**Re: Dutch Brothers Coffee – 210 98<sup>th</sup> St. NW  
Erosion and Sediment Control Plan  
Engineer's Stamp Date 11/30/2022 (K09E048B)**

Based upon the information provided in your submittal received on 12/01/2022, the above referenced ESC Plan cannot be approved until the following comments are addressed.

EROSION AND SEDIMENT CONTROL PLAN

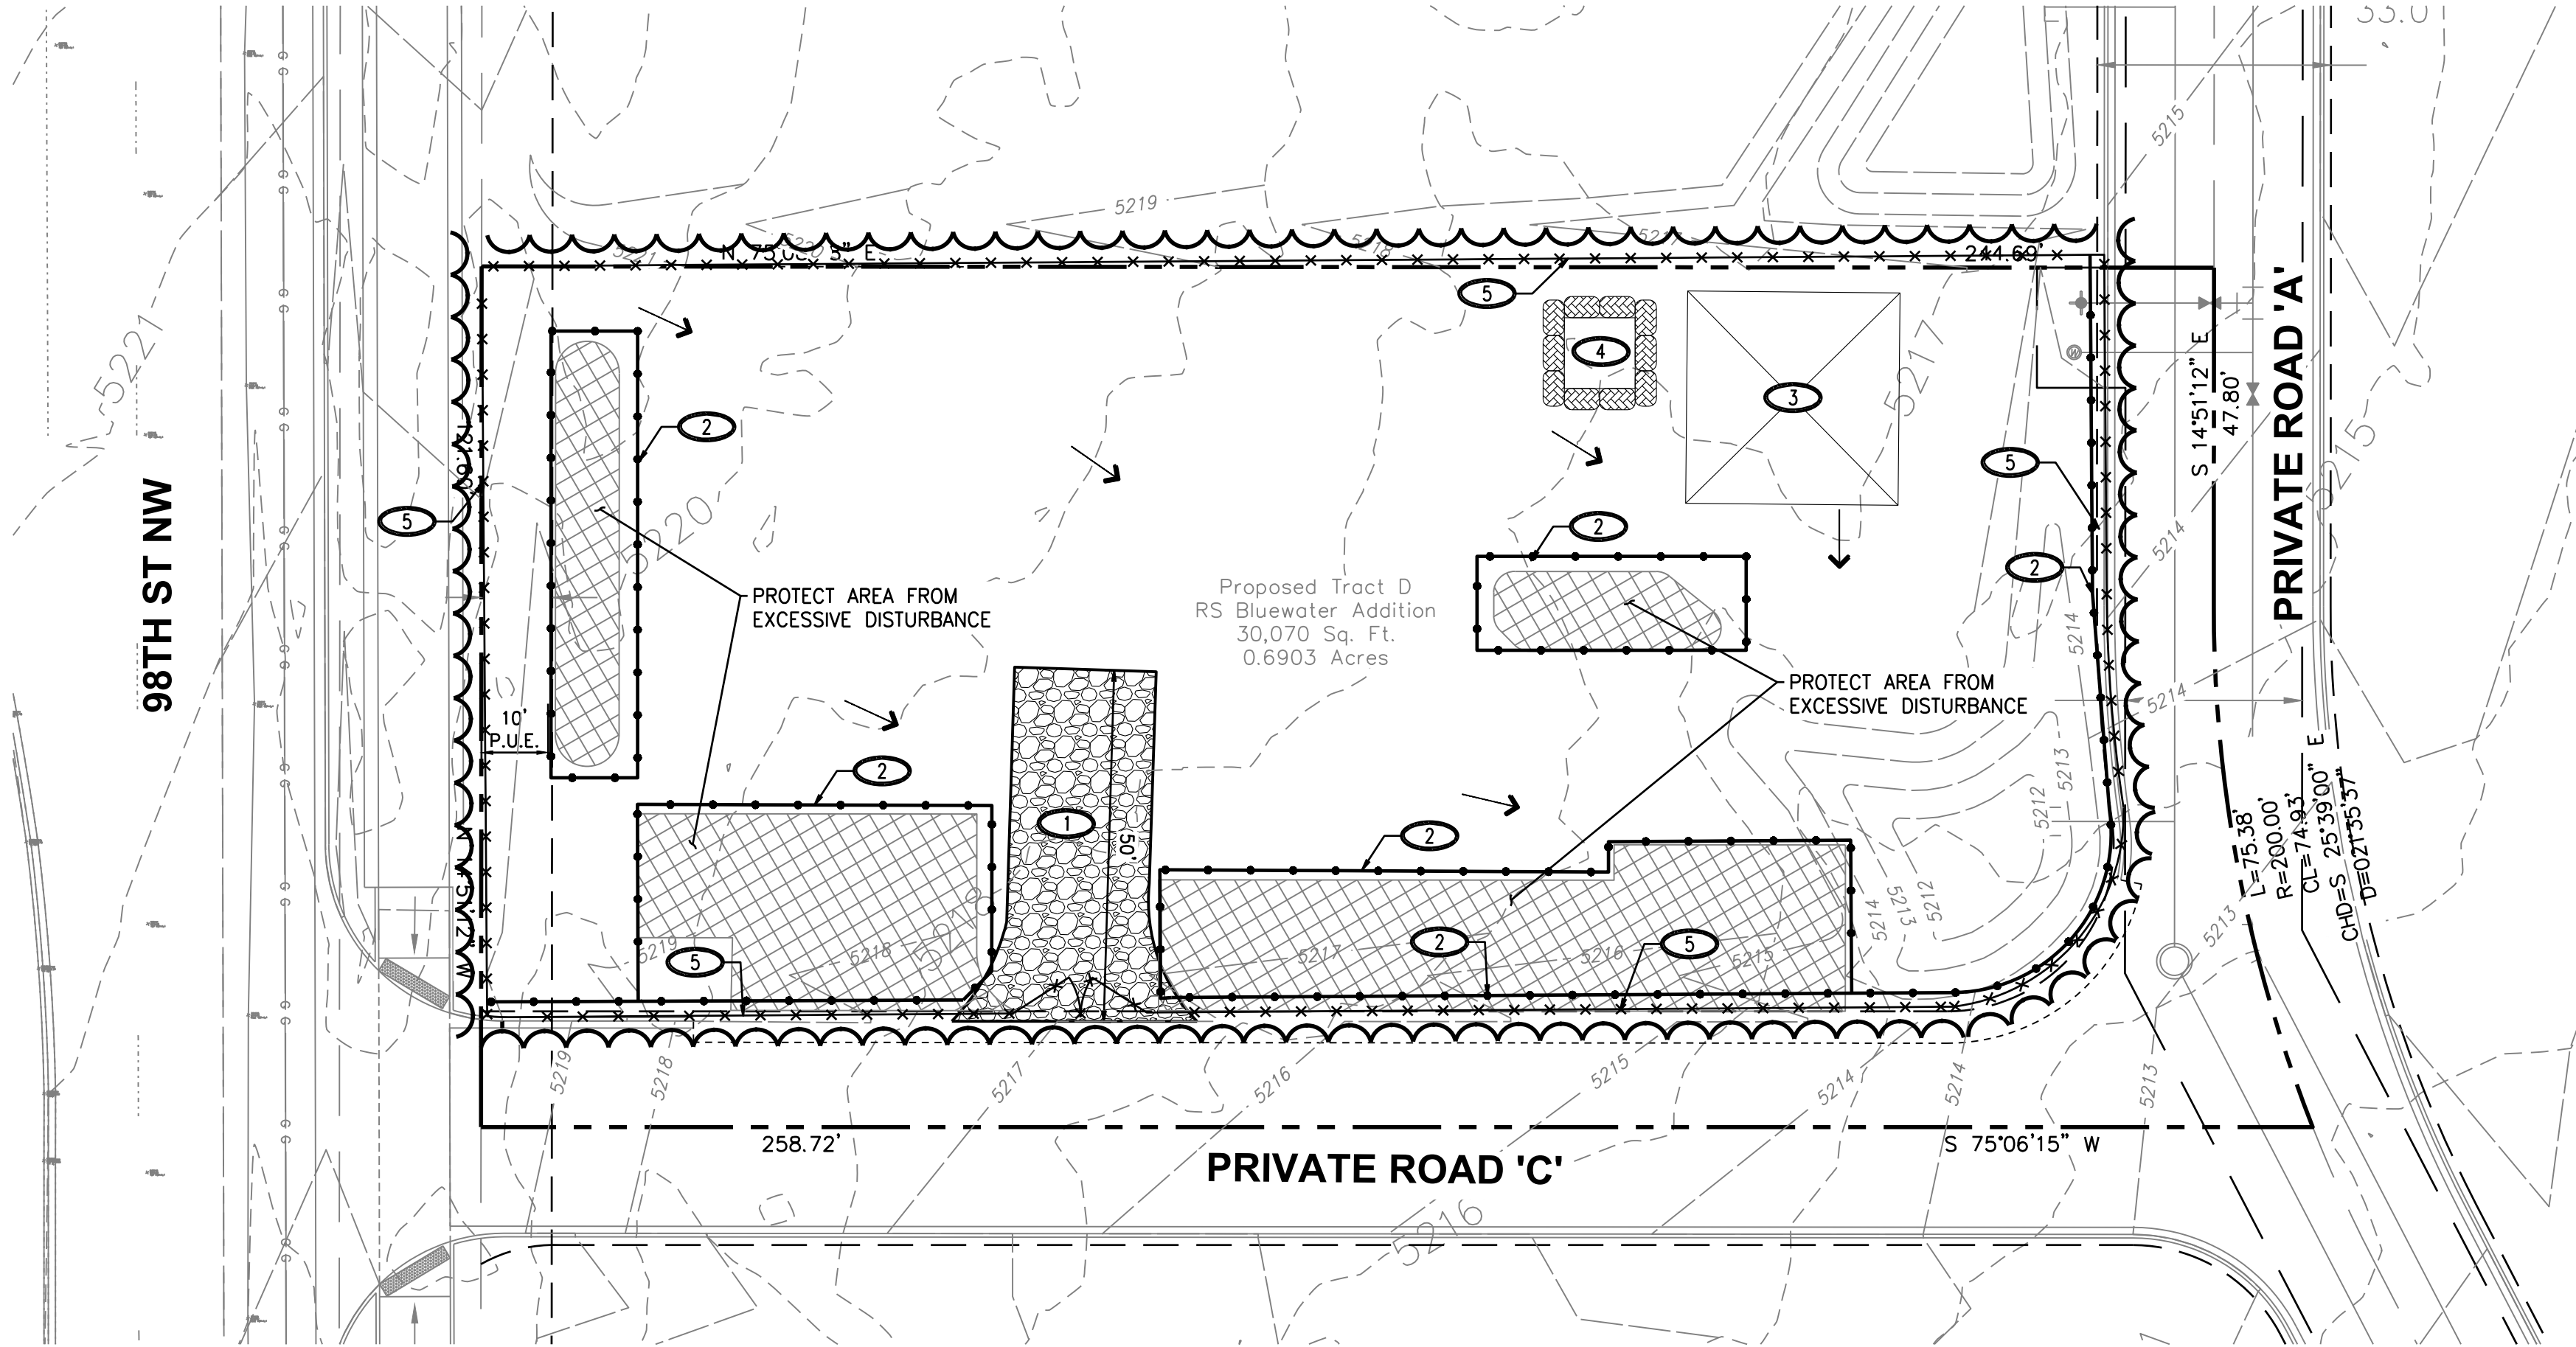
1. A SWQ Information sheet must be included with the submittal.
2. The ESC Plan can't be approved until after Hydrology approves the G&D Plan. The existing and proposed grades must be shown on the ESC Plan, and they must agree with the Grading Plan approved by Hydrology (CGP7.2.4.b.ii).

3. Show all structures on the ESC Plan including the building, sidewalk, and asphalt.
4. This site is part of a "Common Plan of Development or Sale" that exceeds 5 acres, so permit coverage is required even if the site is less than 1 acre and waivers are not available. The ESC Plan can't be approved for Grading or Building Permit until the property owner's NOI has been reviewed and approved by City Stormwater Quality per Albuquerque Code § 14-5-2-11(a). The NOI must be in the SWPPP and available onsite (CGP7.3).

5. Most of this site has already been disturbed so there isn't any benefit to "protecting areas from excessive disturbance" as shown on the ESC Plan. Silt fence is needed as a perimeter control along the streets. Revise based on current site conditions.

6. Describe the nature and extent of construction activities (CGP 7.2.2.). Include a description and project schedule per CGP 7.2.3.f through final stabilization, removal of BMPs, and filing NOT. Also note the size of the property and the total area of land disturbing activities.

7. Soil information – add a table with name type, particle sizes, and Erodibility factor (CGP 2.1.1).
8. Vicinity map – add a zone atlas map clearly indicating location and street names.

9. Update the engineer's stamp date each time the plan is changed.
